DECISION NOTICE

Our Ref: 23/00138/FUL
Your Ref: Alterations and
Reordering - ...

Location:	Paradise Lodge, Weston Under Redcastle, Shrewsbury, Shropshire
Proposed Development:	External alterations to the existing dwelling and the formation of a new external bridged walkway. Repairs of external ground finishes and repointing of masonry
Application No.	23/00138/FUL
Date Received:	13th January 2023
Applicant:	Sir Algernon Heber-Percy

Project	HPC.01	No	3200
Scale (A1)	1:var	Status	4M
		Revision	2

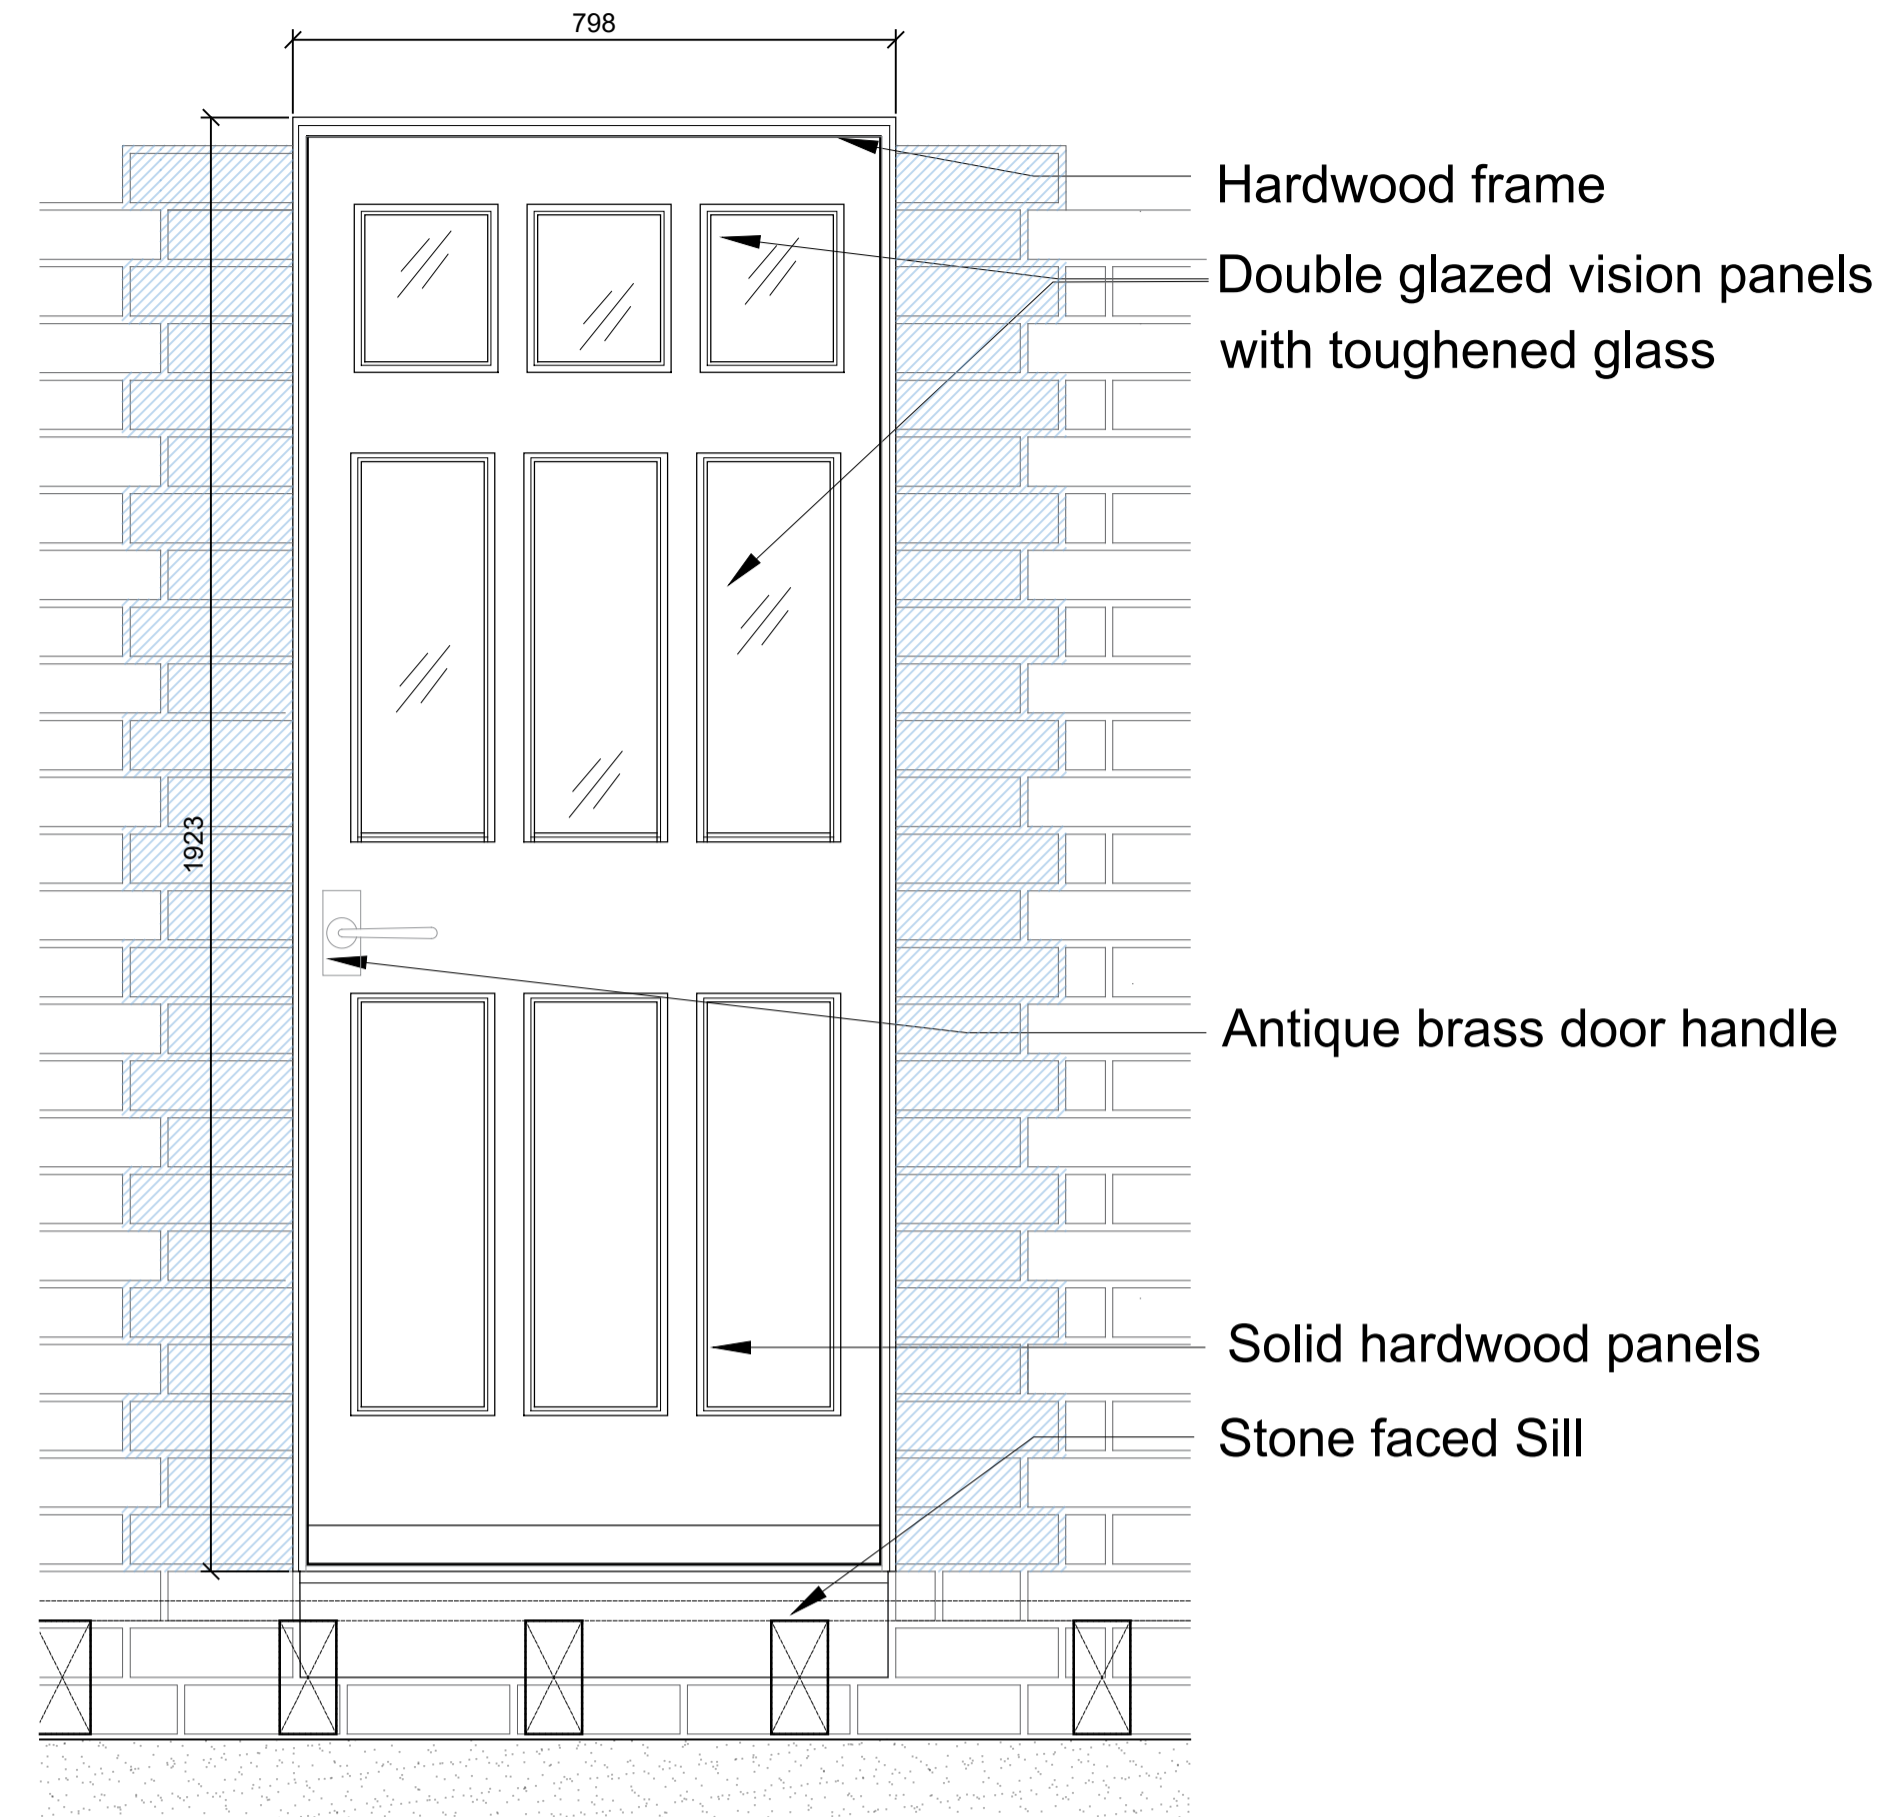
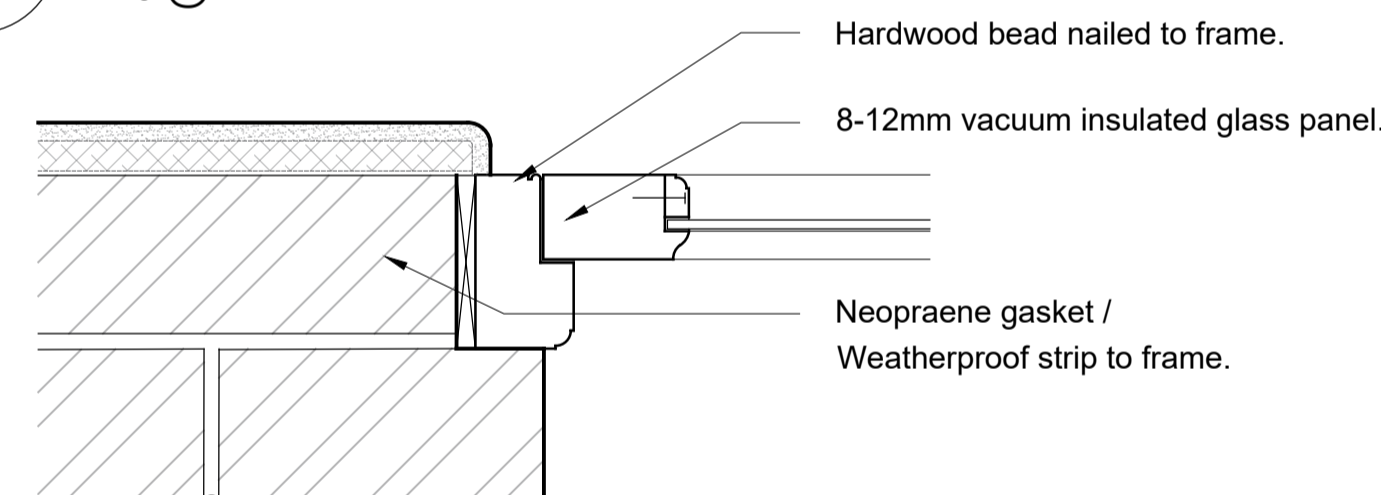
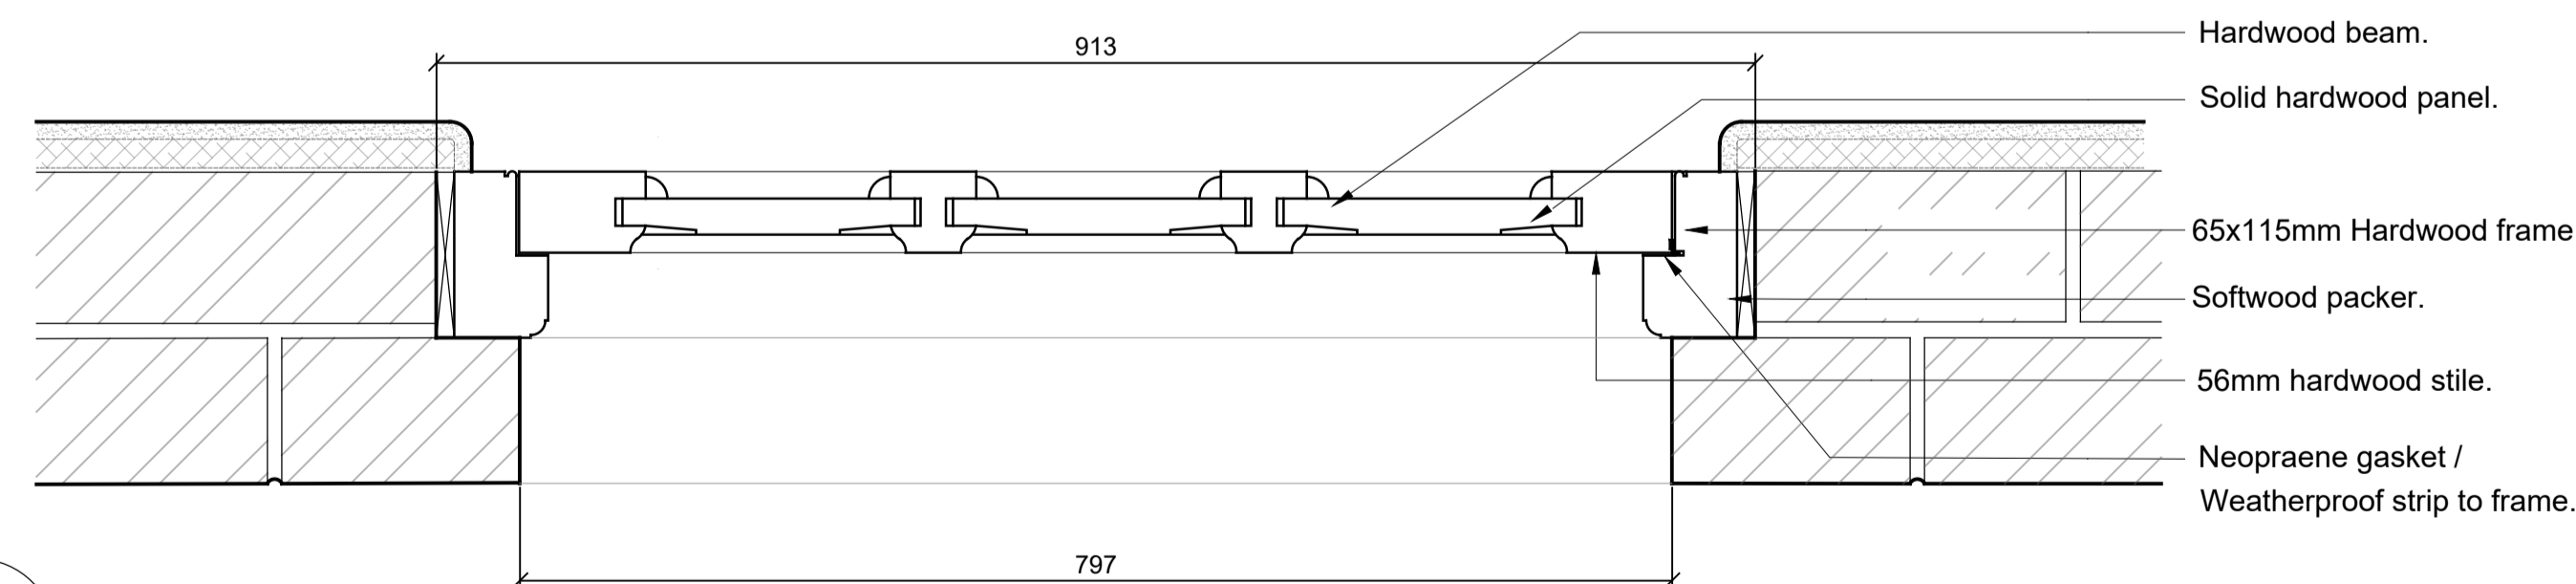
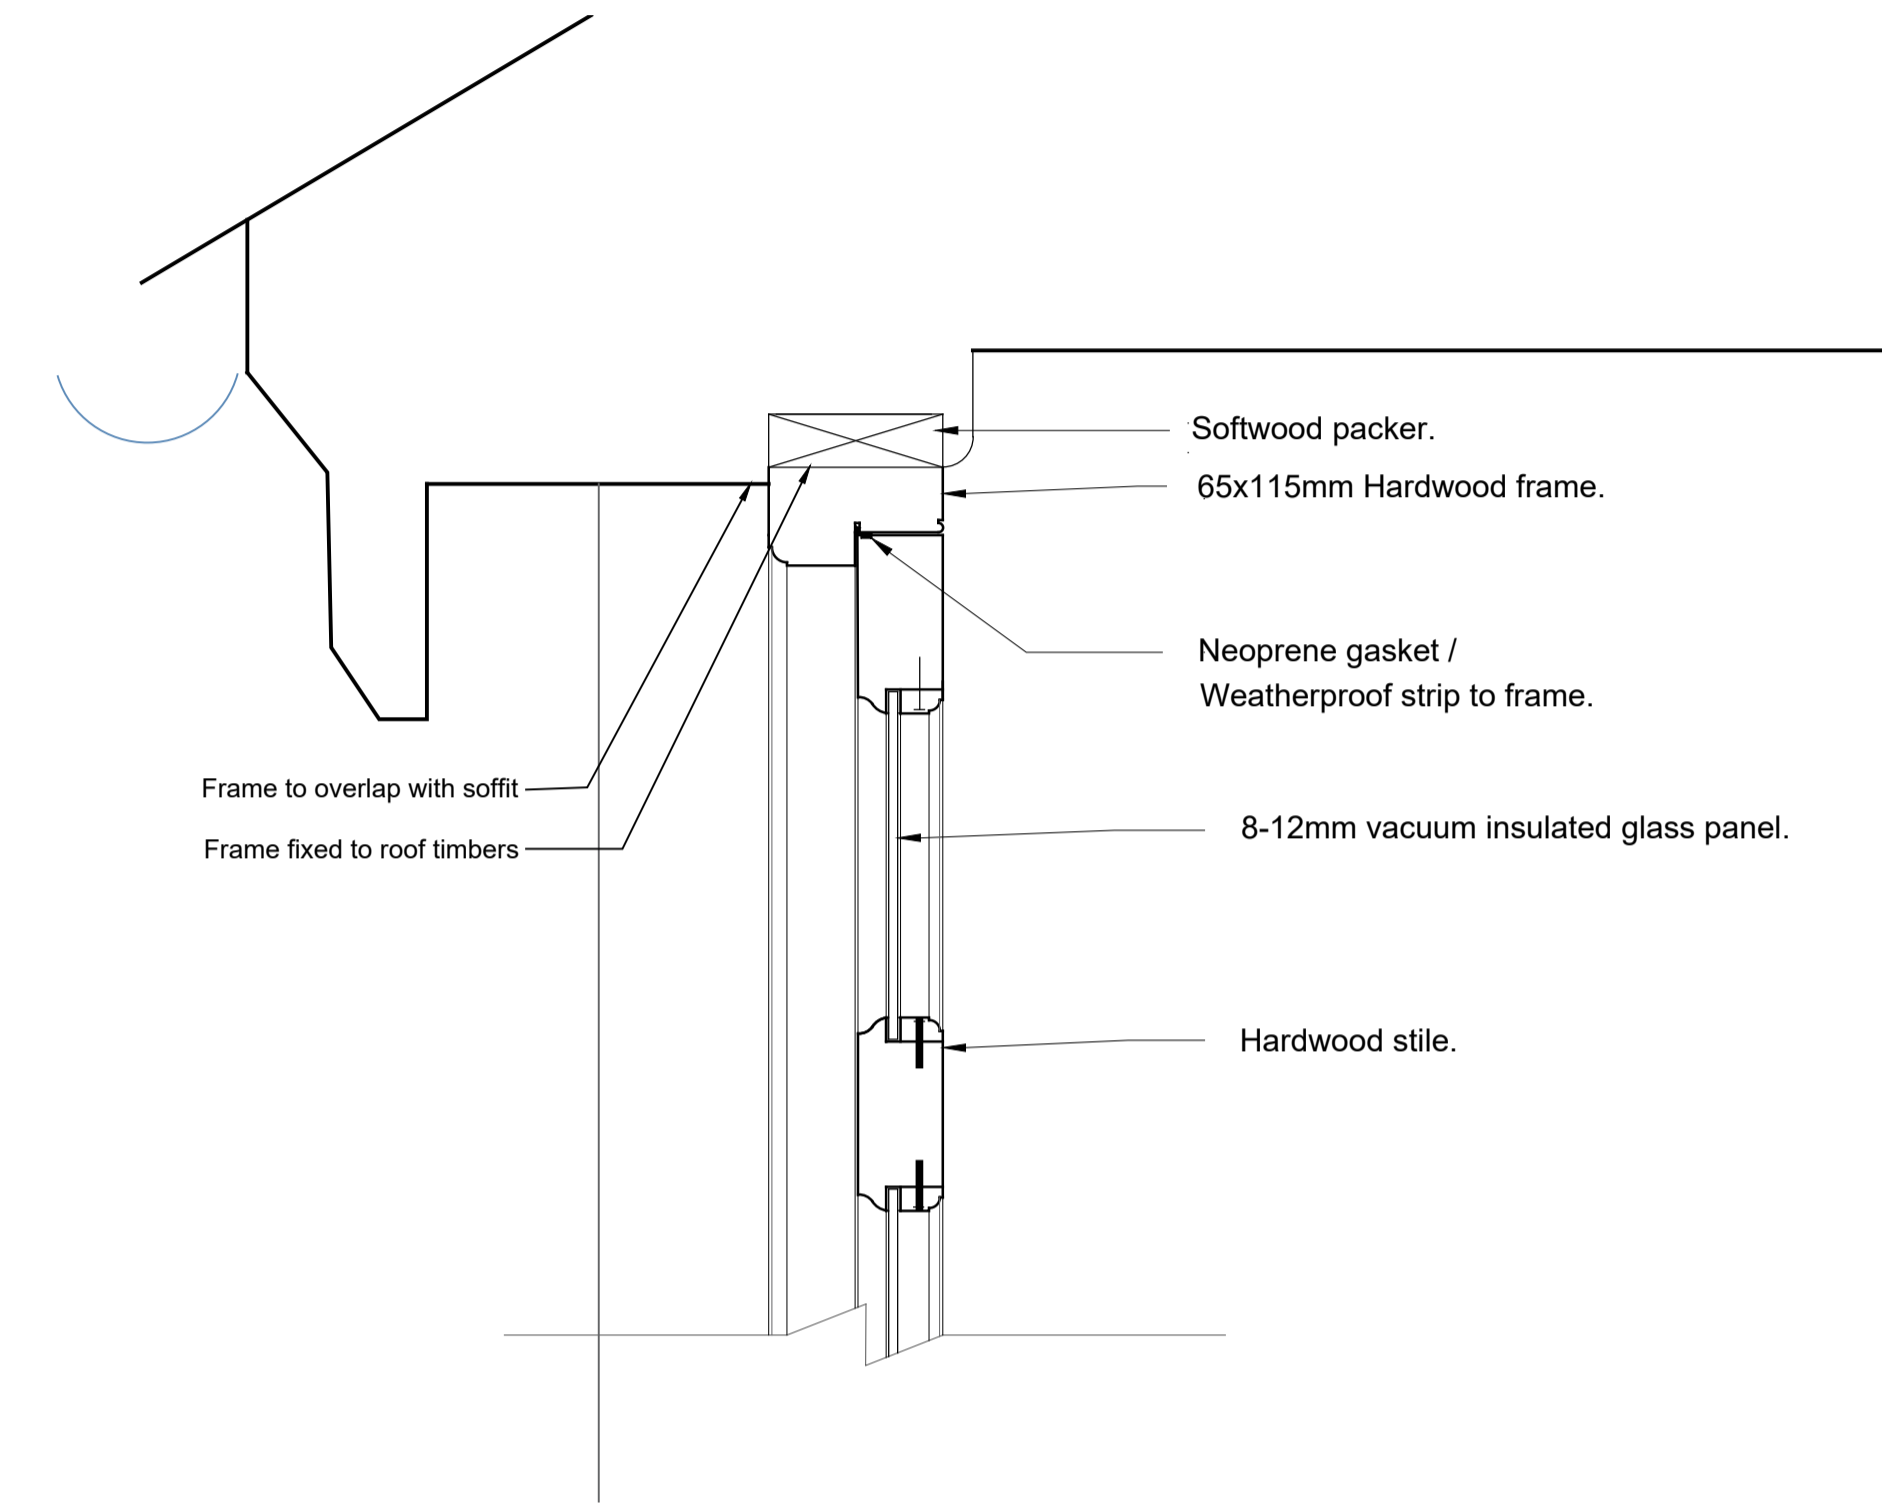
8. Notwithstanding the detail shown on drawing numbers 3201 and 3202, details of all external windows and doors and any other external joinery shall be submitted to and approved in writing by the Local Planning Authority prior to the commencement of the relevant work. These shall include full size details, 1:20 sections and 1:20 elevations of each joinery item which shall then be indexed on elevations on the approved drawings. All doors and windows shall be carried out in complete accordance with the agreed details
